Transport  
for NSW

**Dubbo Hospital Redevelopment Stage 4, Myall Street, Dubbo (SSD 7720)**  
**Notice of Exhibition**

## **Appendix A – Comments on Dubbo Health Service Redevelopment Stage 4 State Significant Development Transport Assessment (Appendix H)**

DUBBO HOSPITAL REDEVELOPMENT
GROUND FLOOR
14.5m BUS SWEPT PATH ASSESSMENT

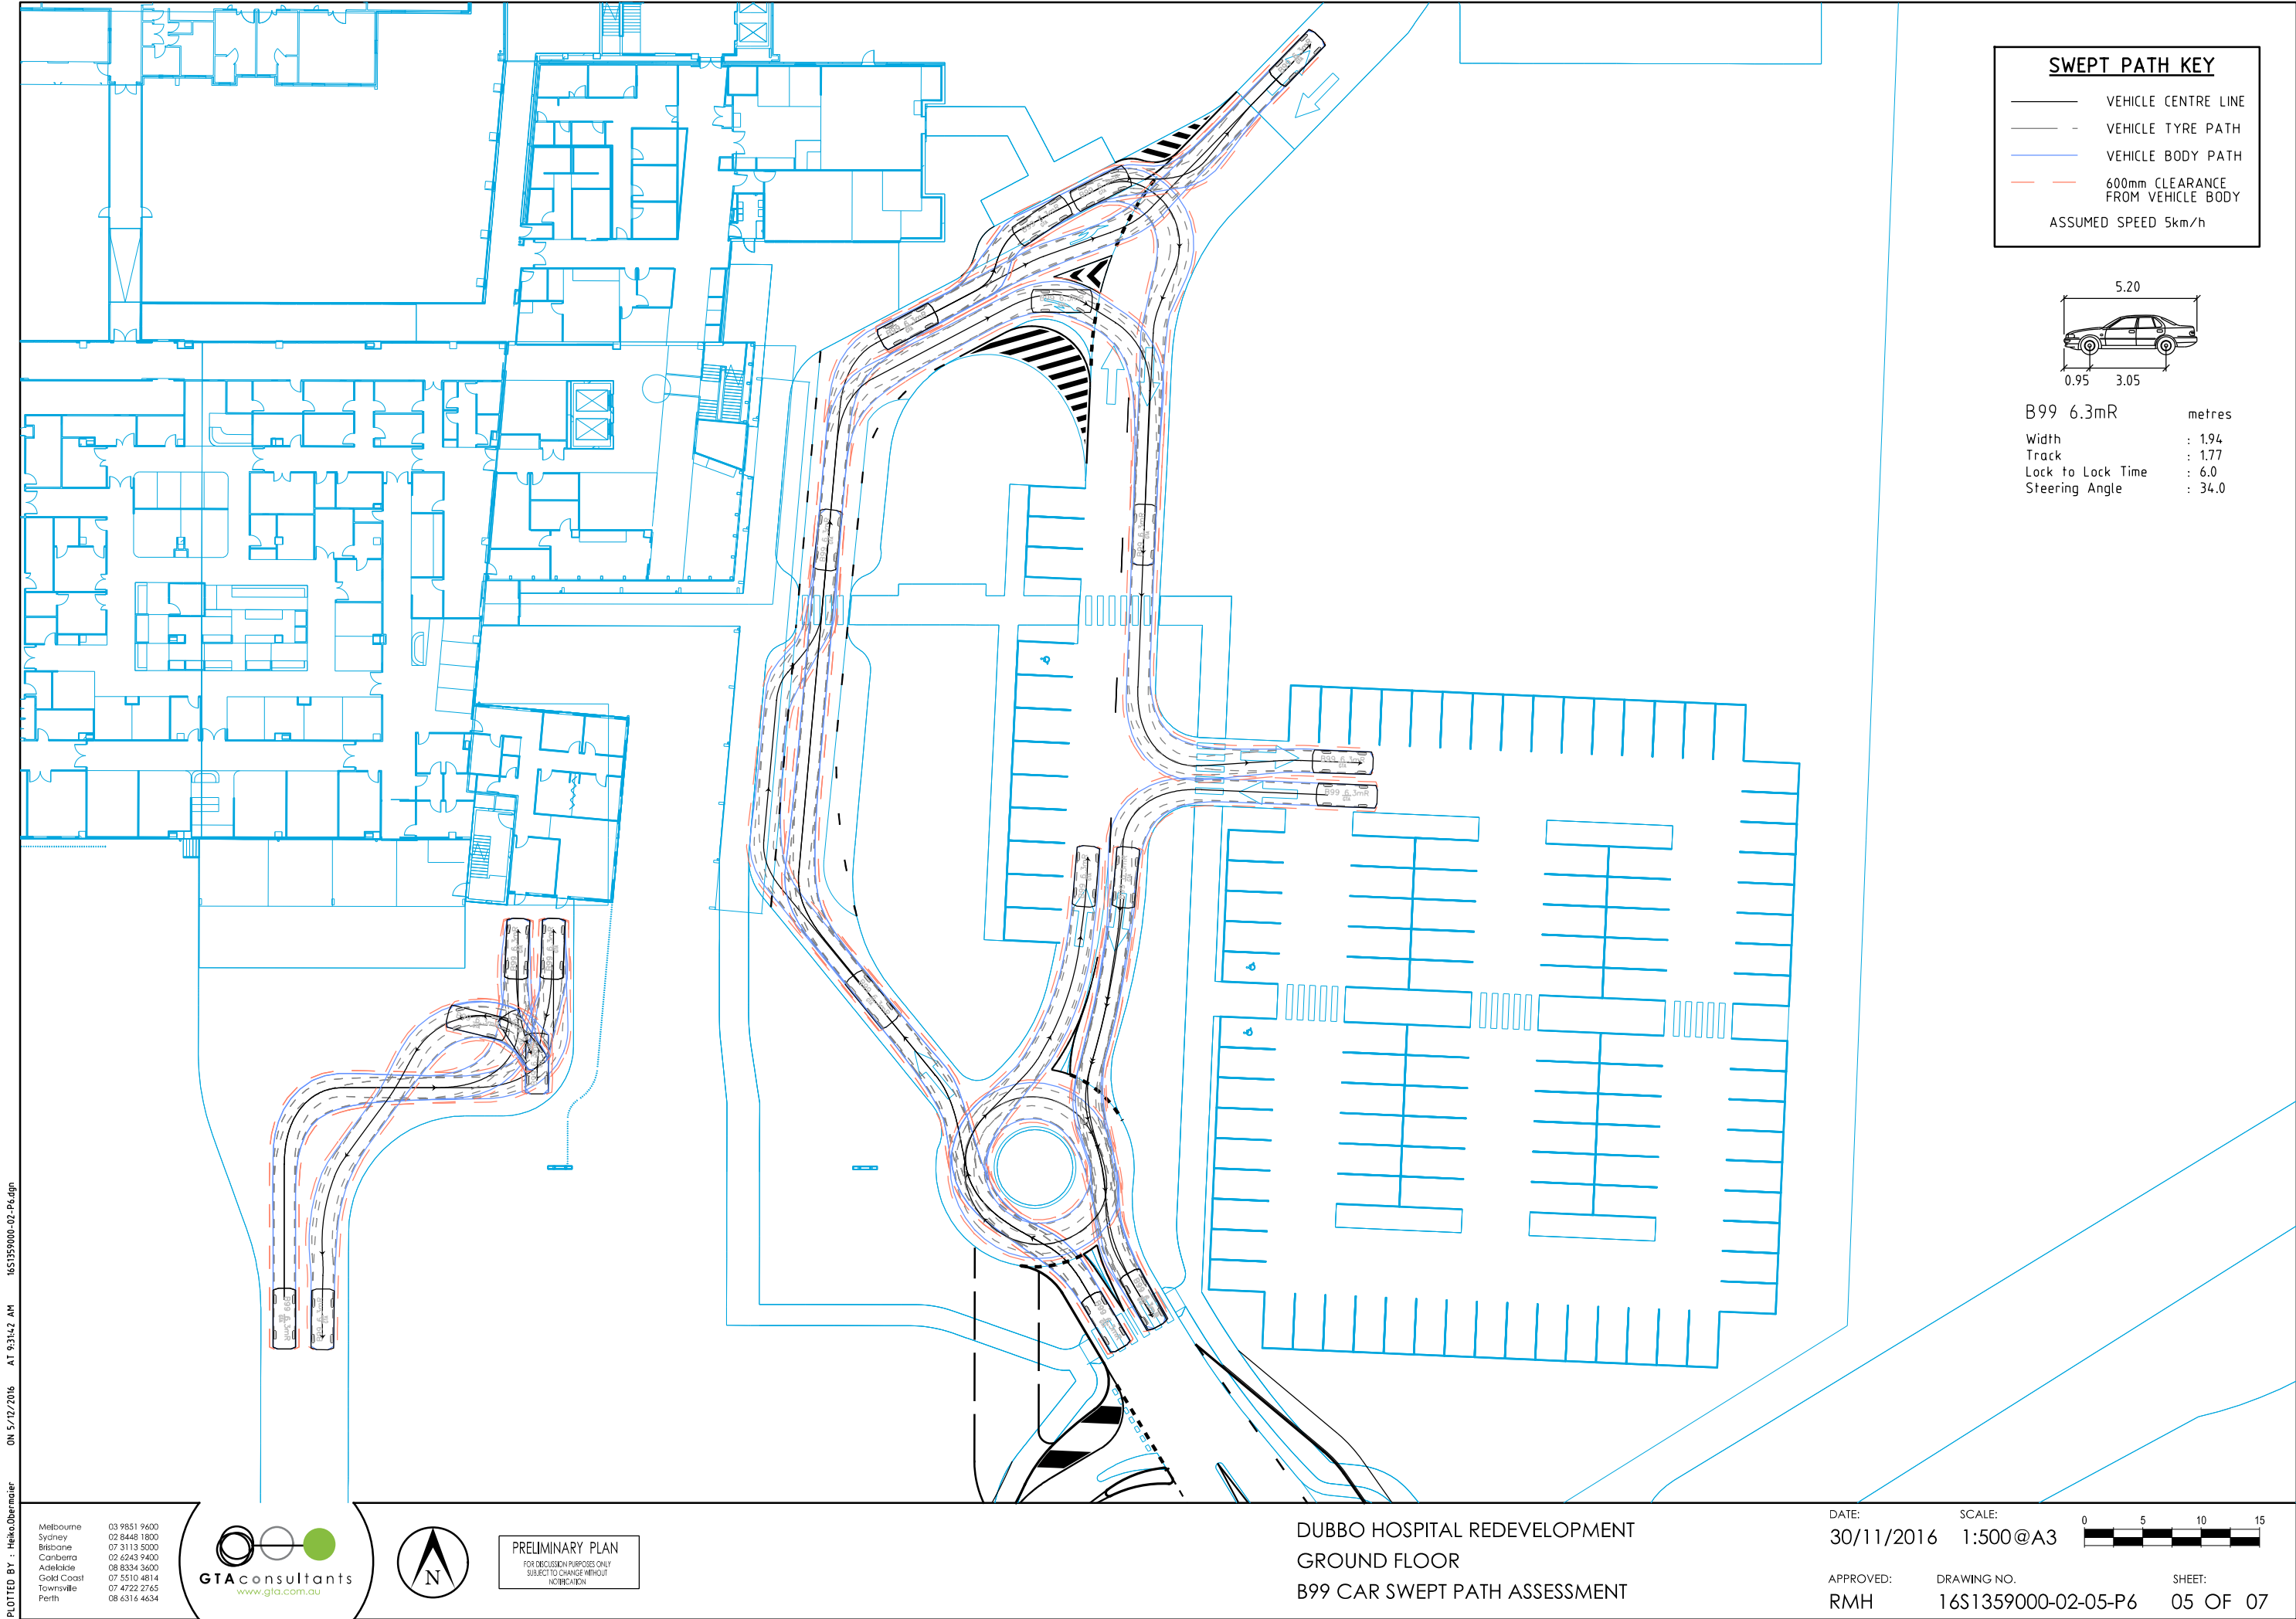
The TIA indicates that the site is within close proximity to transit stops positioned on Cobbora Road/Golden Highway. It is noted that there is no formal transit stop or supporting infrastructure at this location such as shelters or formal pedestrian connections. TfNSW would consider diverting existing bus operations via the site,

if the appropriate infrastructure is made available – namely transit stops and bus capable roads. TfNSW believes that this would provide increased pedestrian safety, moreover, encouraging and attracting users of the development to utilise public transport. Figure 1, illustrates a possible diversion route through the site.

TfNSW recommends greater supporting infrastructure for safer pedestrian amenity and bus operations.
